Hinckley & Bosworth Borough Council
Interested Party Reference Number: 20039546

**REP4 – 133: Doc 18.14 Applicant's response to HBBC and
BDC deadline 3 submission on design matters**

**Application by Tritax Symmetry (Hinckley) Limited for an
Order Granting Development Consent for the Hinckley
National Rail Freight Interchange**

Landscape Design

Fig 6. Parameters Plan and Key

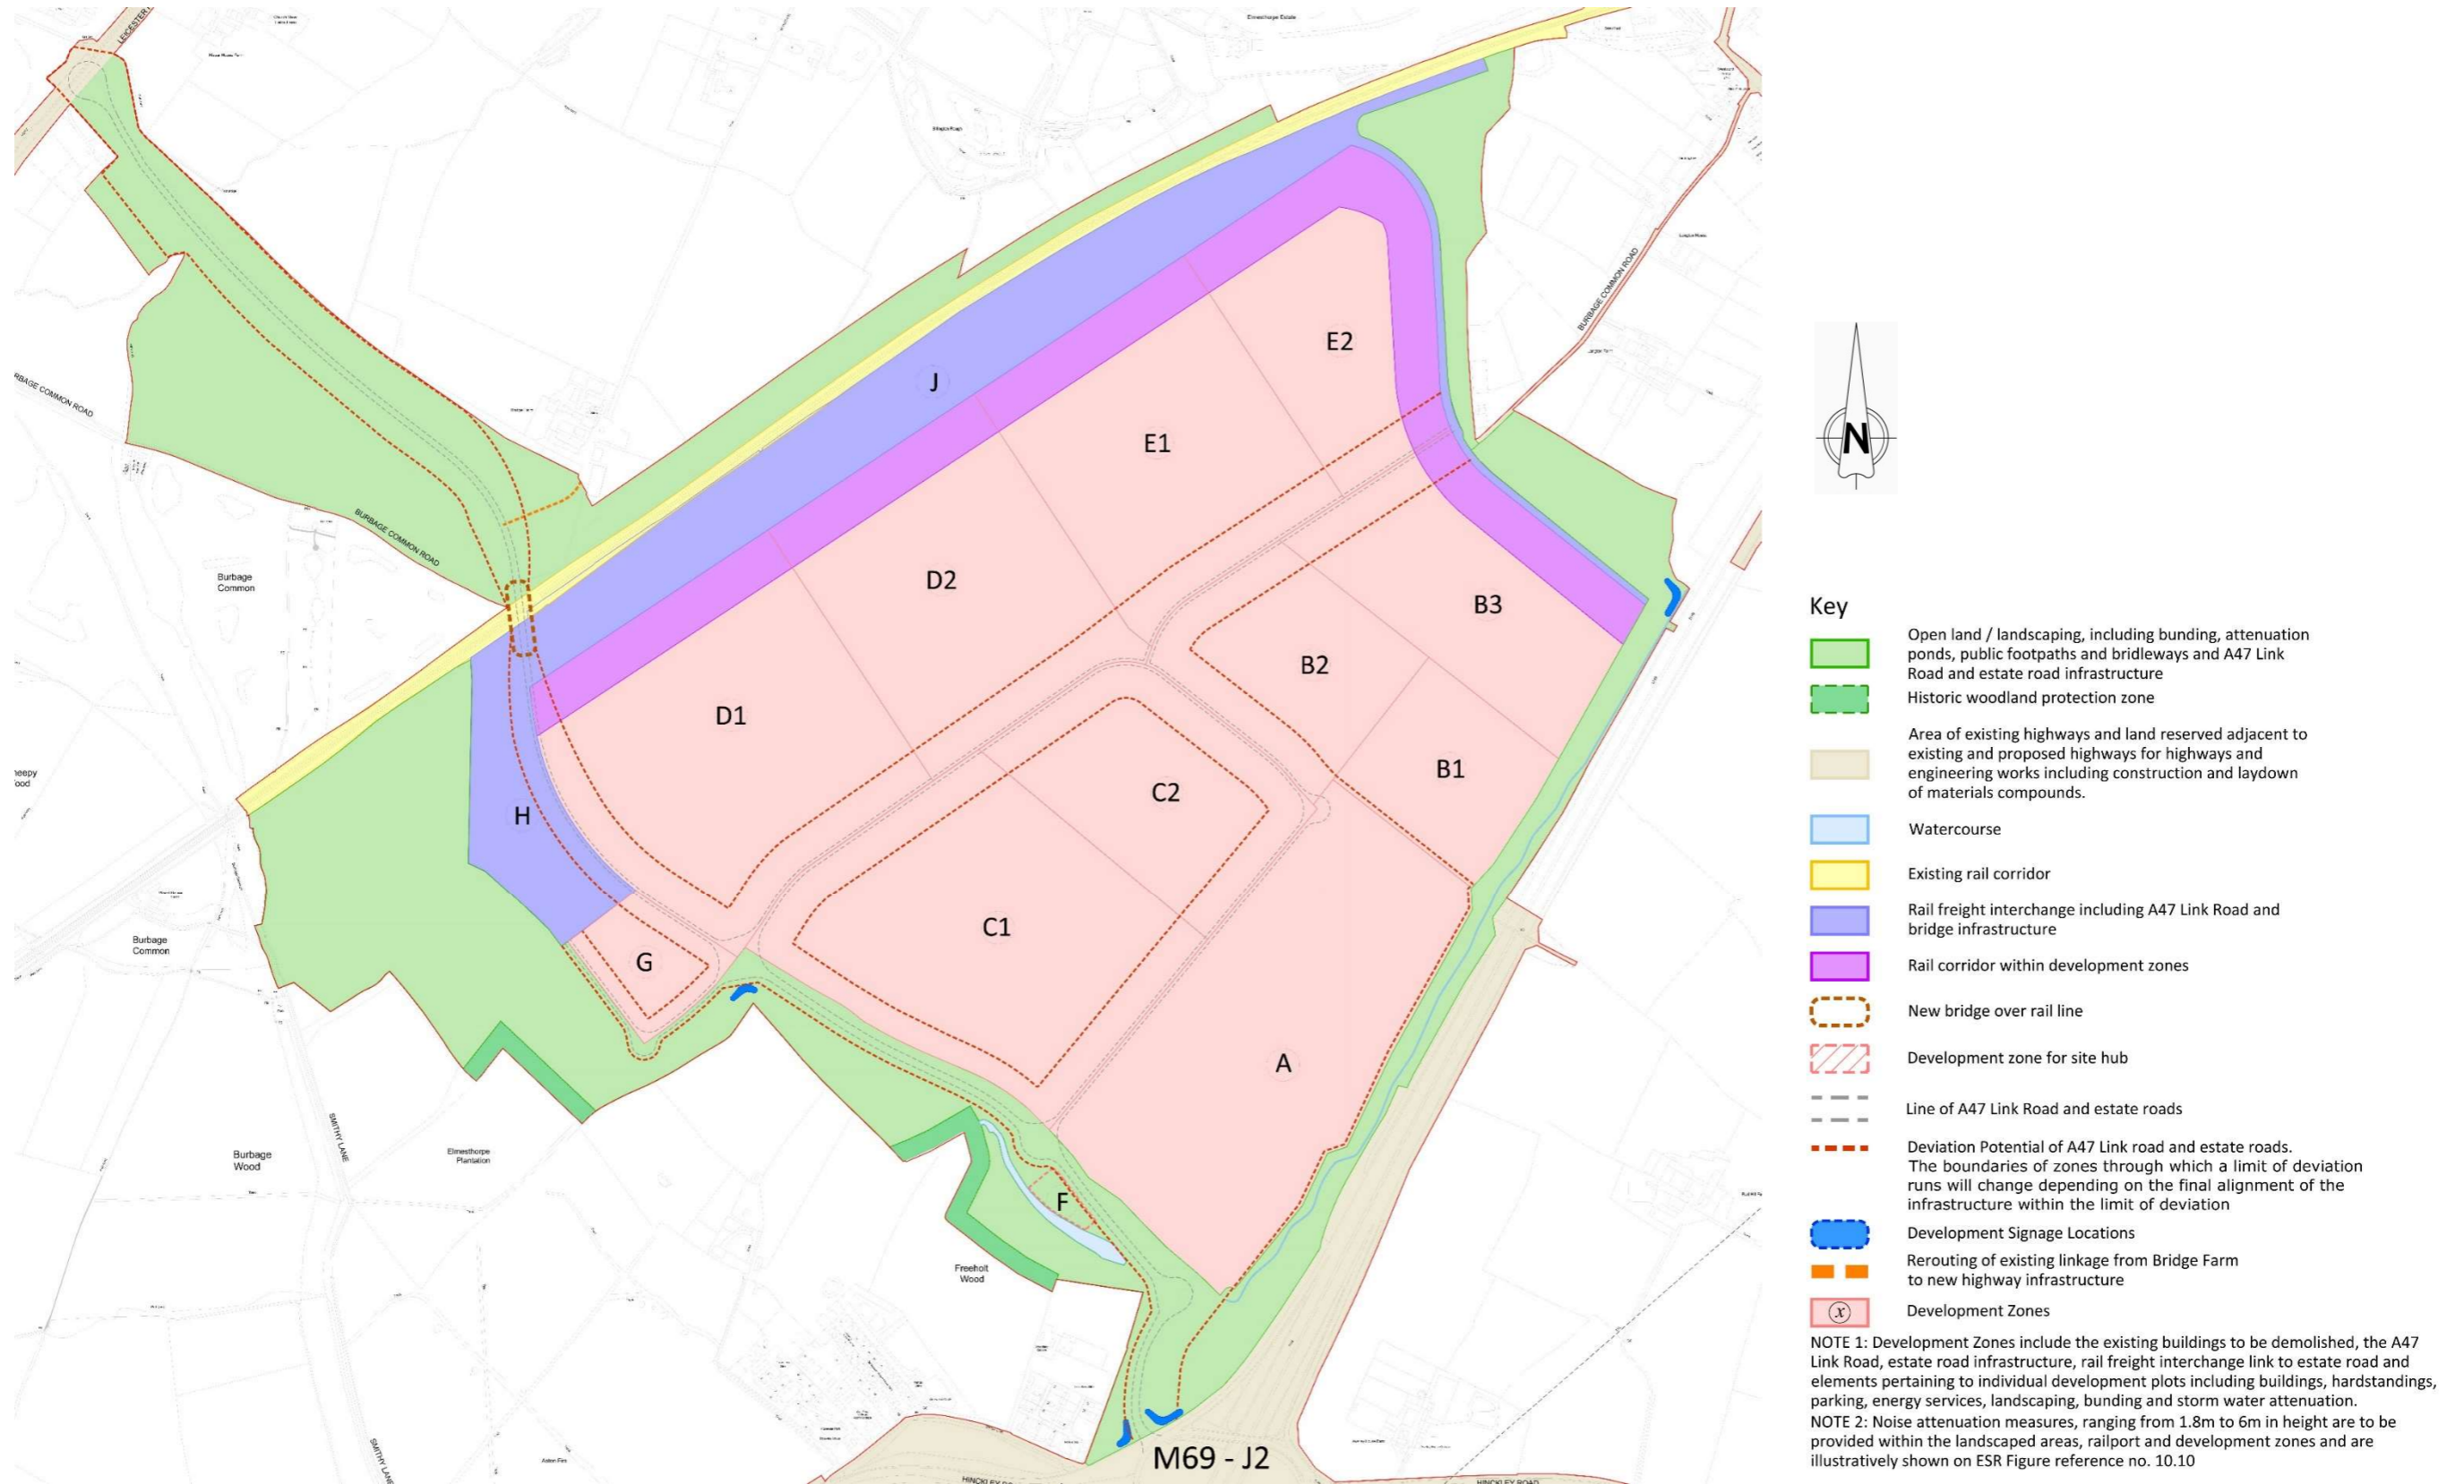
Page 12, section 3.1	Point 32	The point made previously, was that the parameters plan did not seem to show the same evolutionary process as the illustrative masterplan did, however this is not the case, and the Parameters Plan did indeed keep in step with the evolution of scheme.	No change to document wording – the point previously raised that despite comments outlined in the original LUC design report regarding character, scale, impact on nature and the locality (also raised independently by other parties during consultation), the scheme doesn't appear to have taken these comments into consideration.
Page 14, section 4.1	Point 33 & 36	<p>An SRFI requires a uniformity within which the Railport, serving infrastructure and development plots can be laid out within. Notwithstanding the larger scale that an SRFI dictates, and as was noted at the ISH, only smaller, non rail served developments, could seek to achieve this.</p> <p>This point is not correct, and none of the previous iterations of the masterplan retained the veteran tree.</p>	<p>Noted</p> <p>Noted</p>
